NORFOLK BOREAS OFFSHORE WIND FARM

Planning Inspectorate Reference: EN010087

Natural England's response to
DCO documents submitted at Deadline 5 and 6

31st March 2020

Title:
Transects in designated ecological sites
(Map 3 of 15)

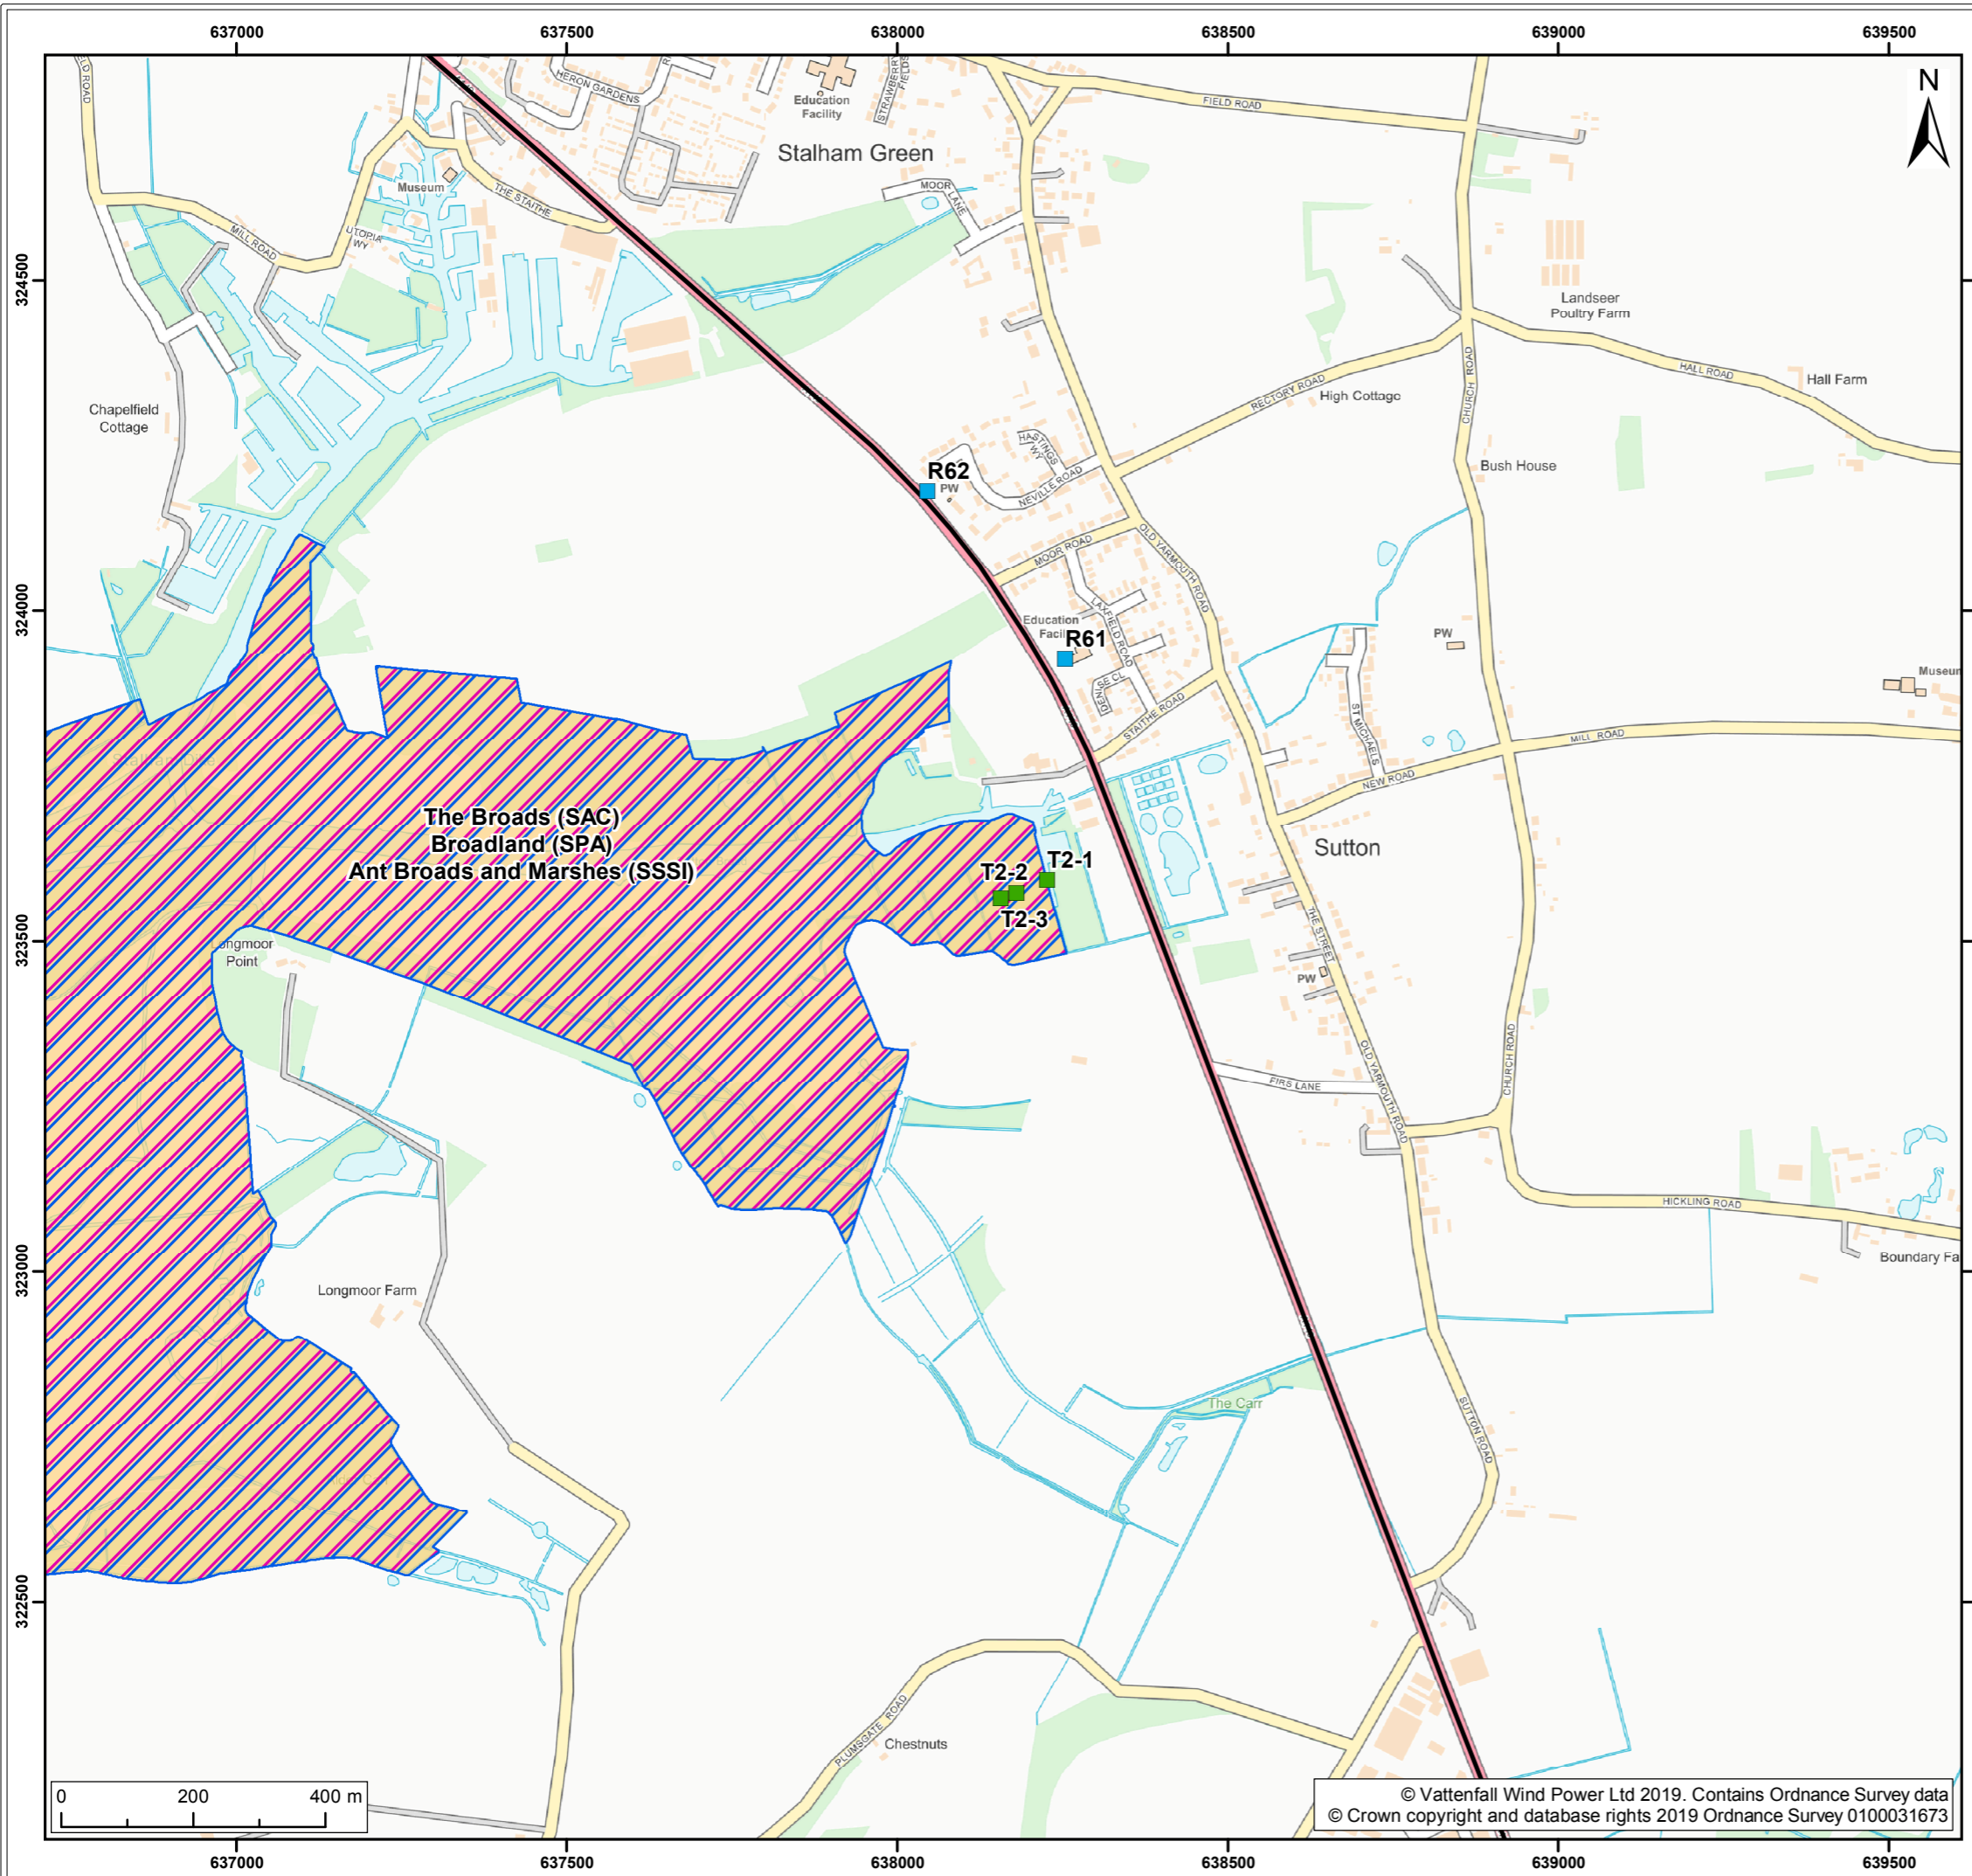
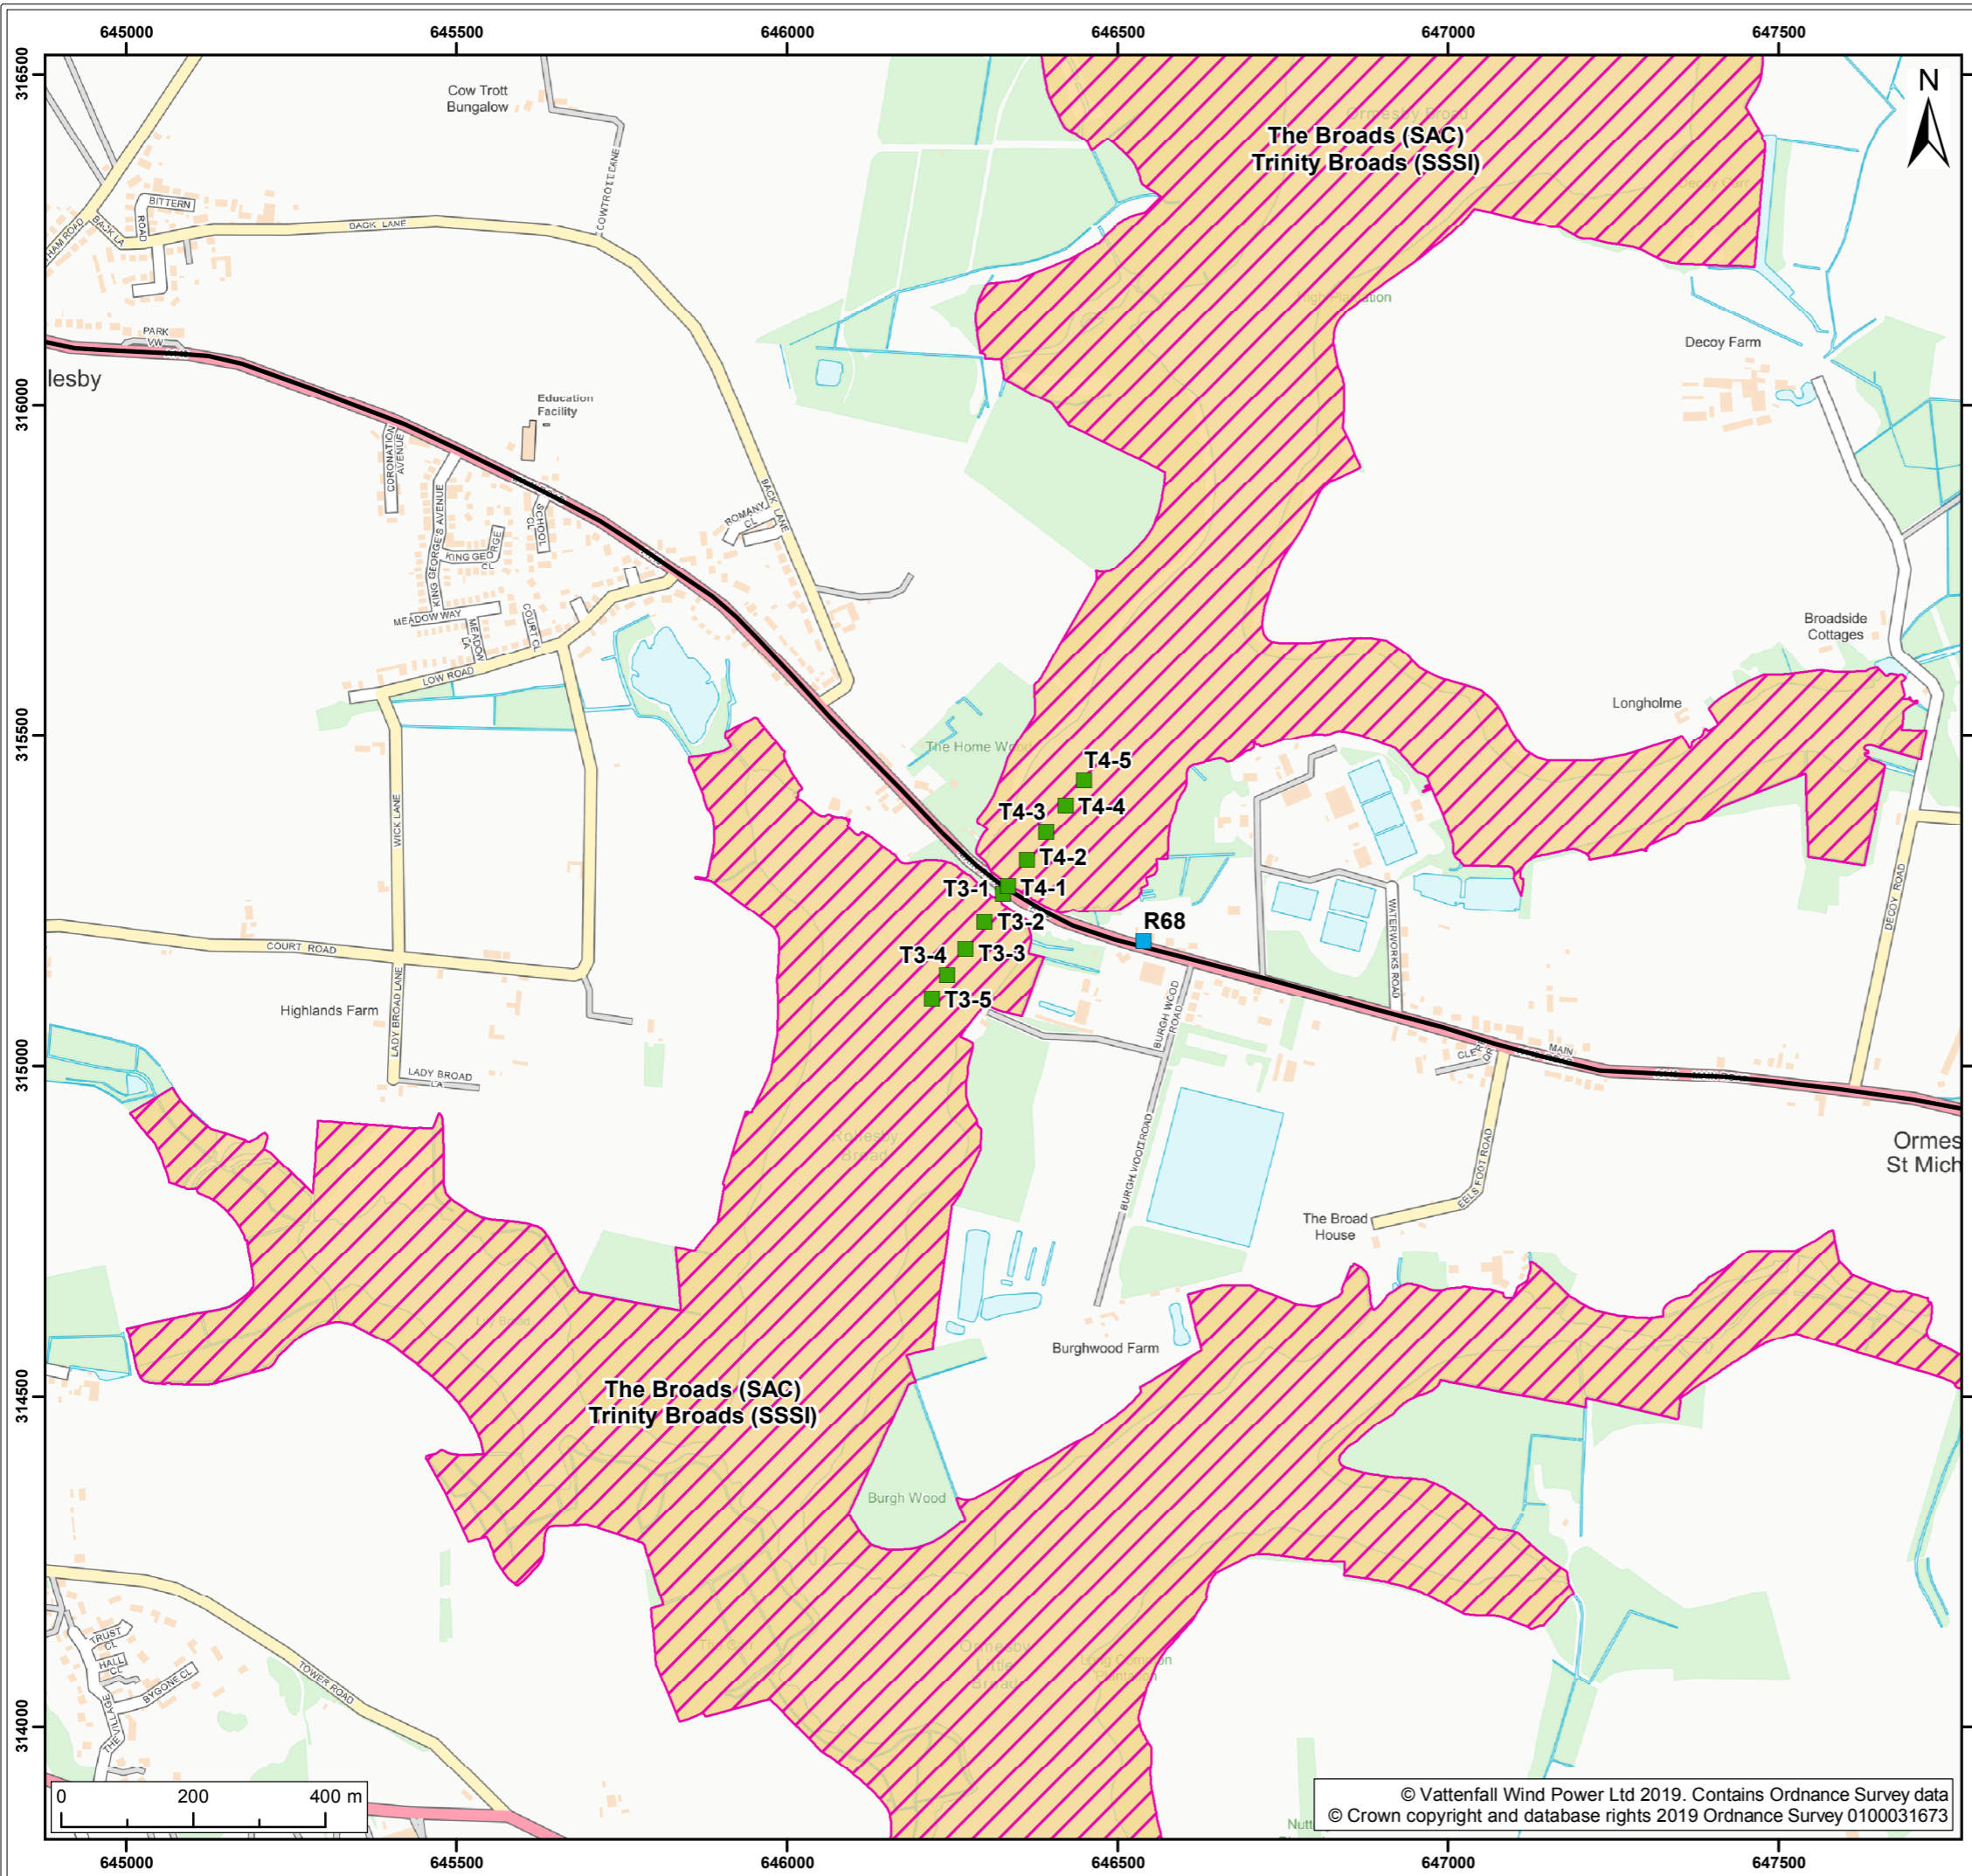
8.8 Outline Traffic Management Plan Version 3		
74	17	Welcome inclusion of para 74 in OTMP, advise that the Applicant include ES figure 26.5 as an Appendix to the OTMP to allow reference should the ES not be publicly available by the time of construction.
		This does not show the location of designated sites sensitive to air quality in relation to the traffic and HGV routes, either alone or in combination with other developments. Advise that the Applicant include ES figure 26.5 as an Appendix to the OTMP.
